DRB Project Number: 2021-004968
Kimmick and Paseo del Norte

SUBJECT: Extension of Preliminary Plat

Project Name: La Cuentista Subdivision

Extension of Preliminary Plat (Second Extension)

PRELIMINARY PLAT LA CUENTISTA SUBDIVISION (REPLAT OF TRACT B-1-A AND TRACT B-2-A)

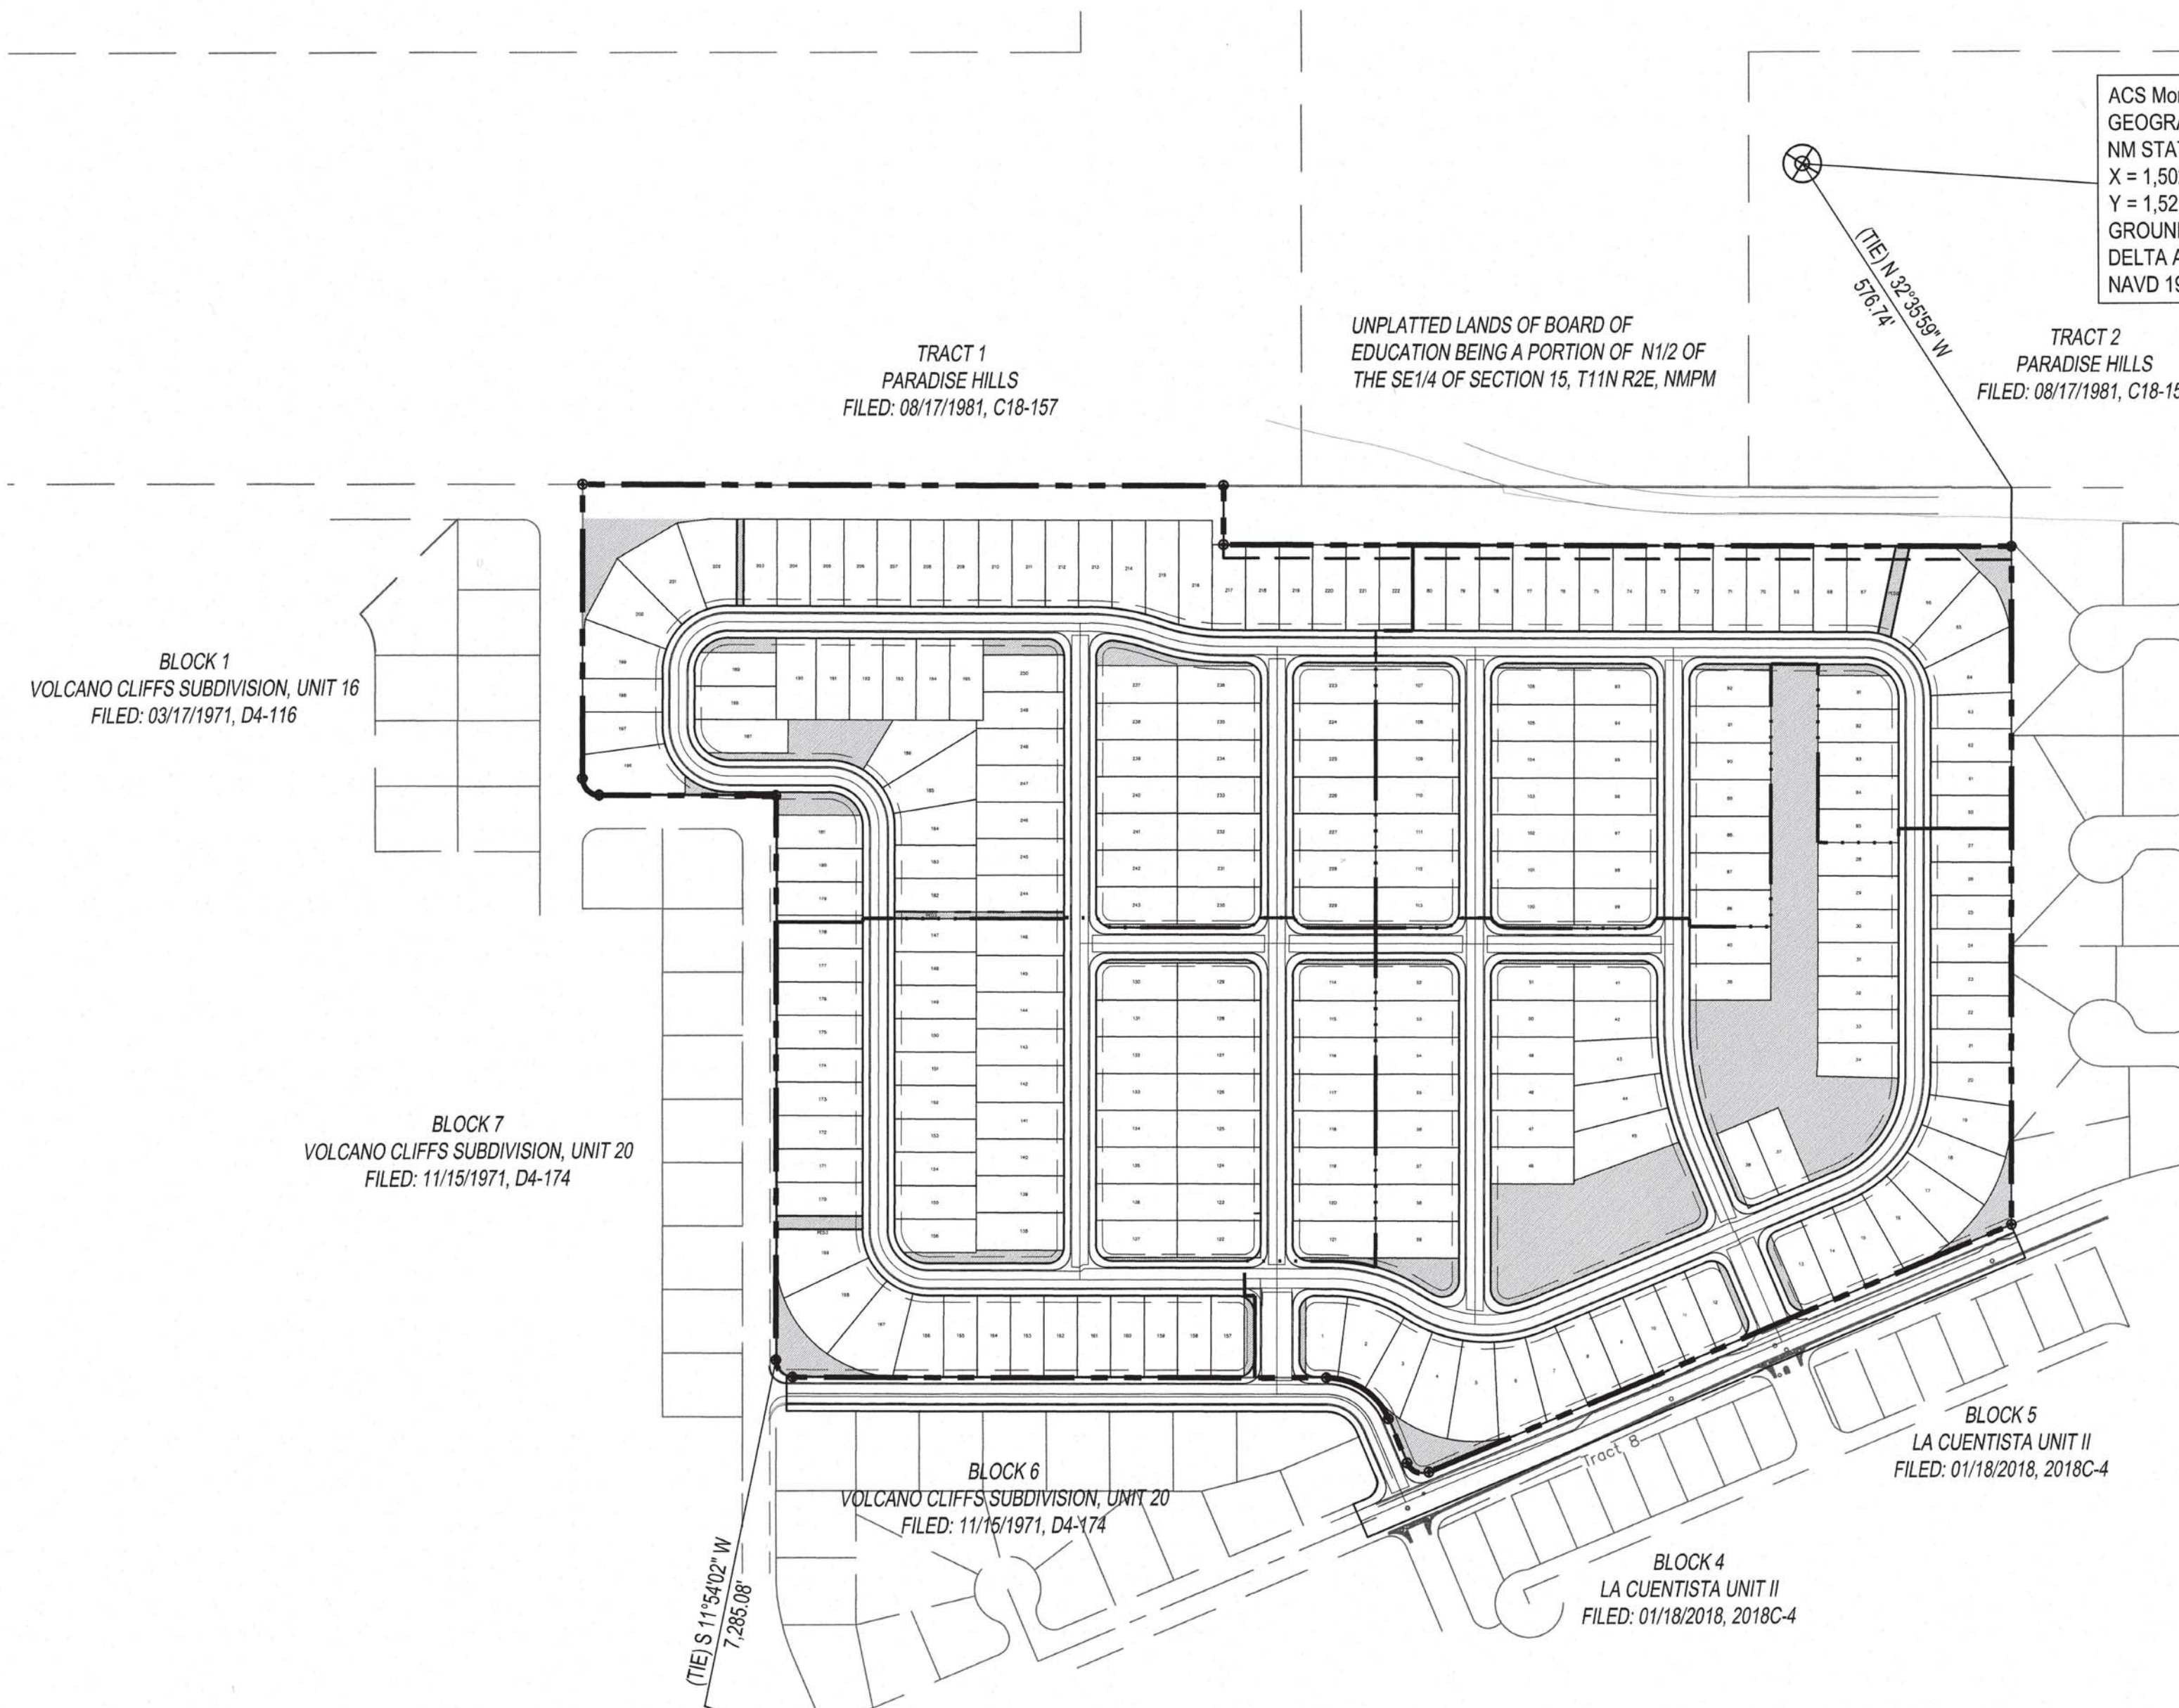
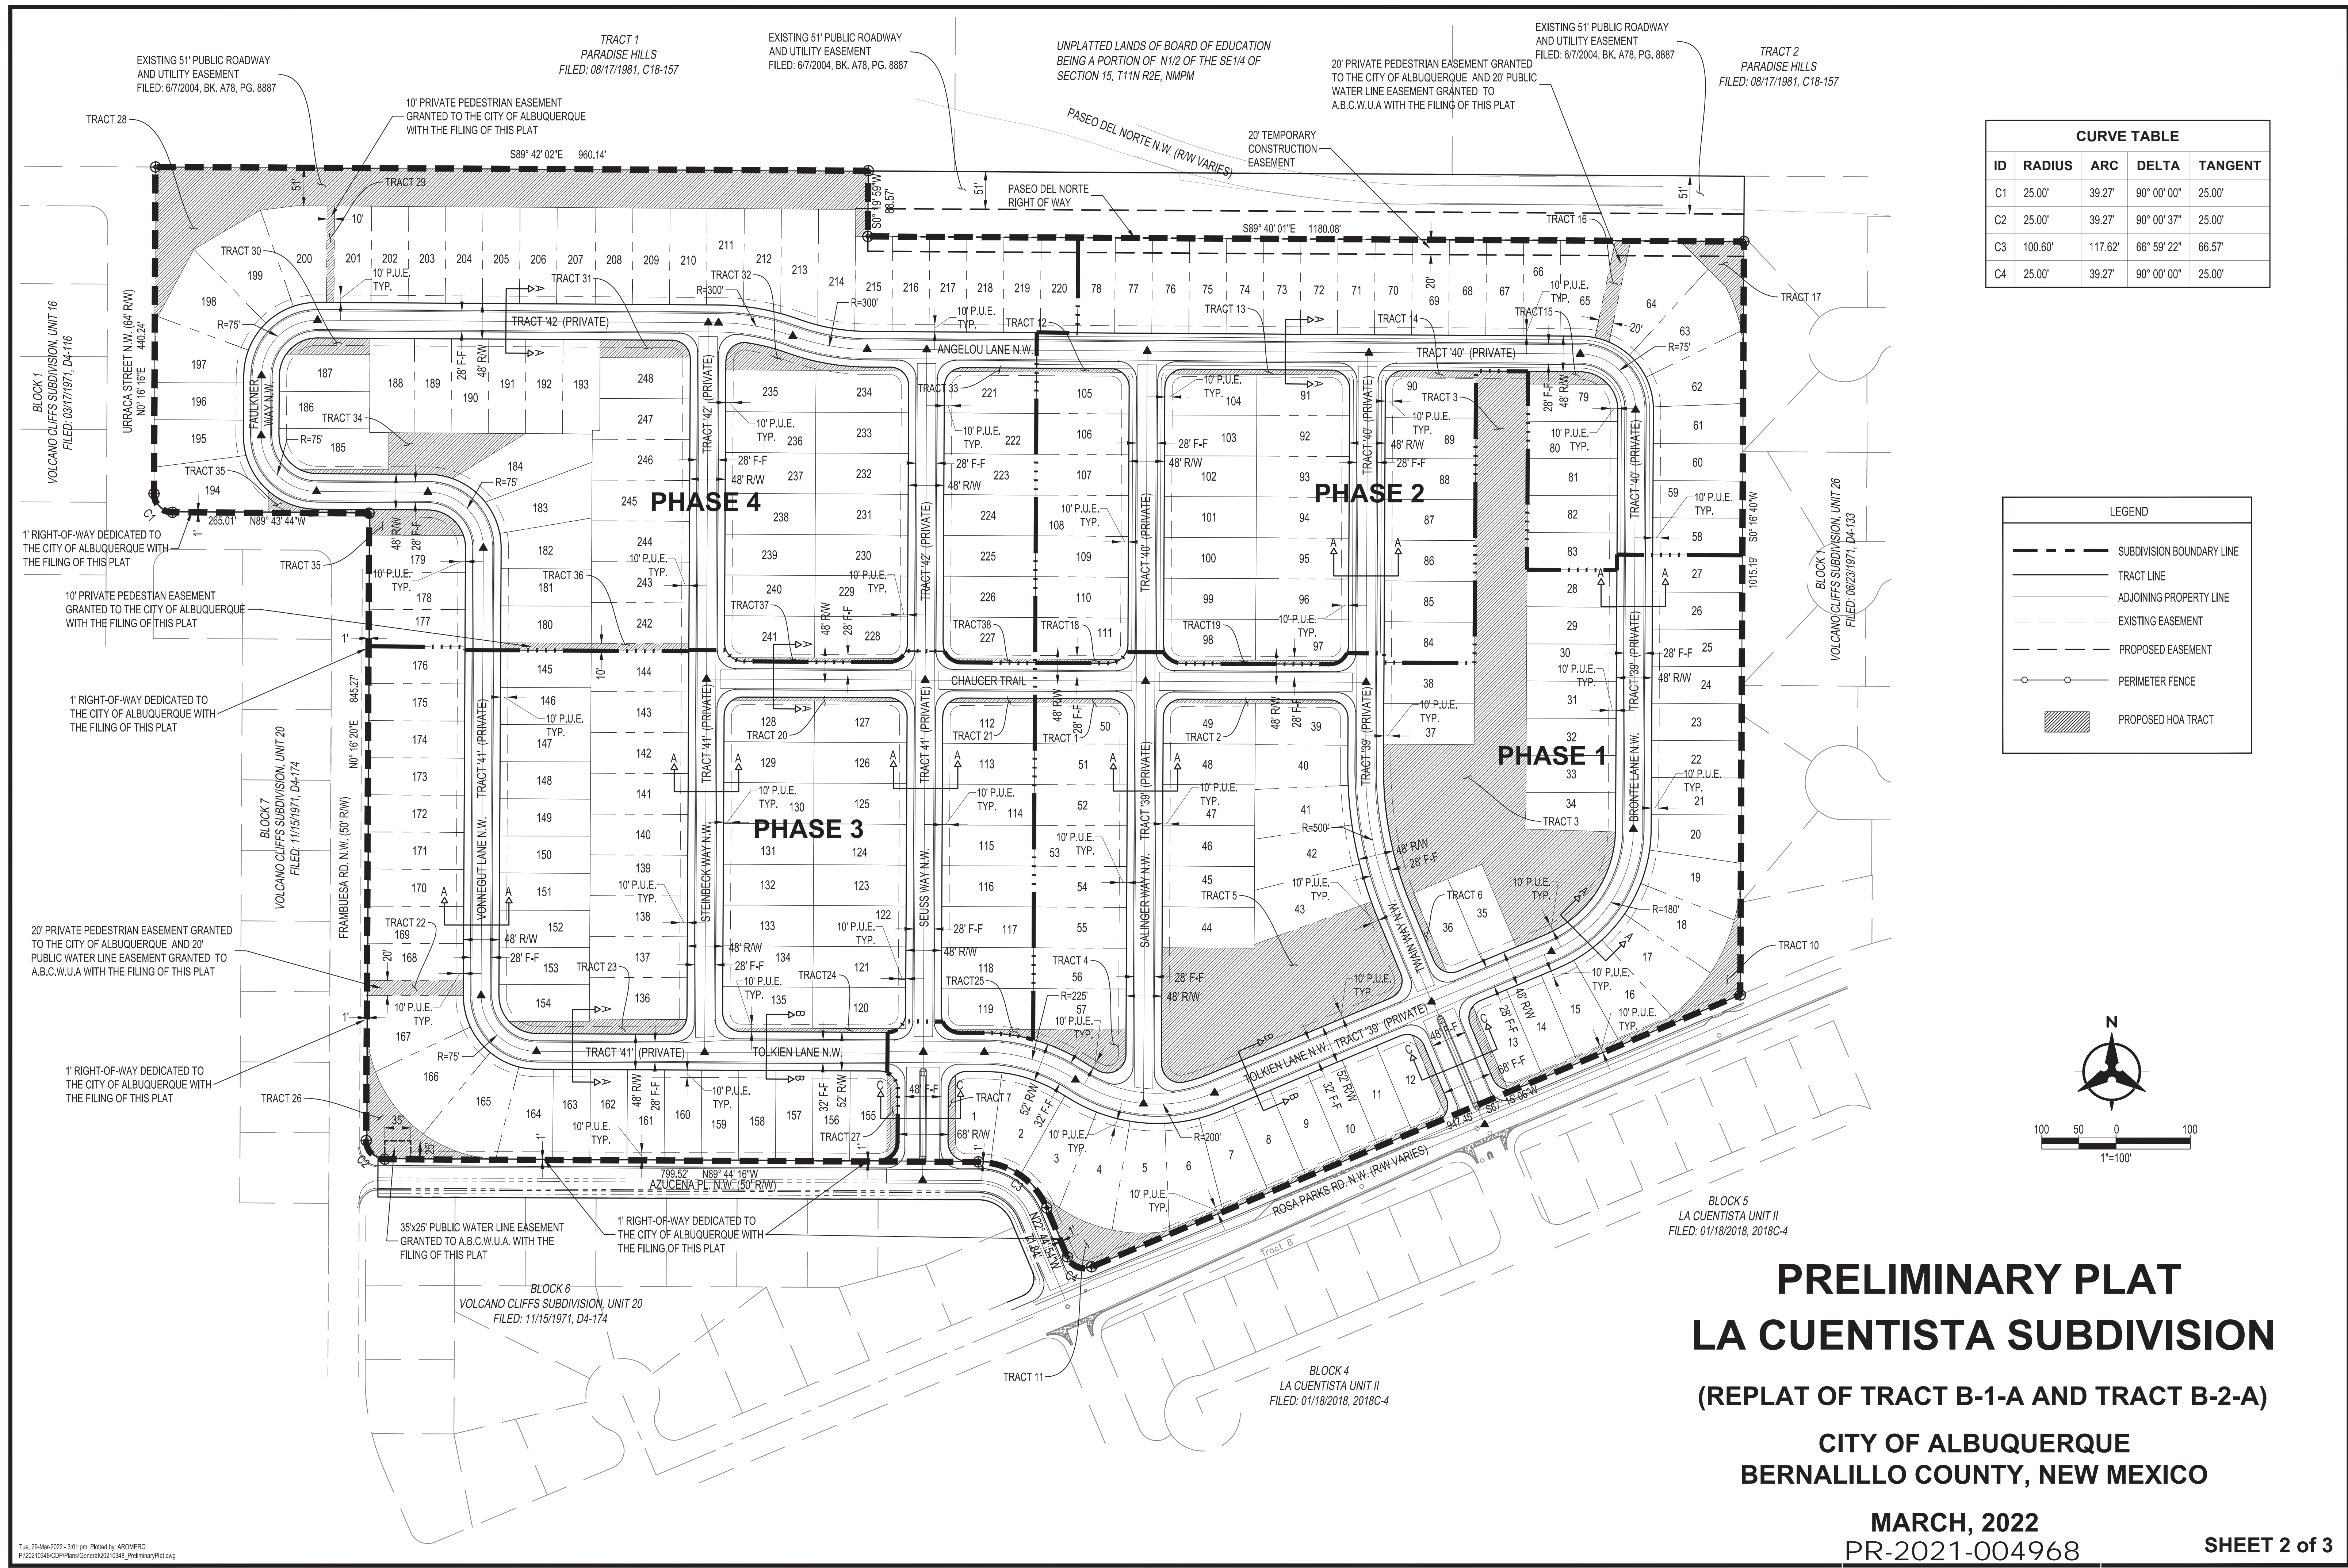
- Please add the project and application numbers to the plat.
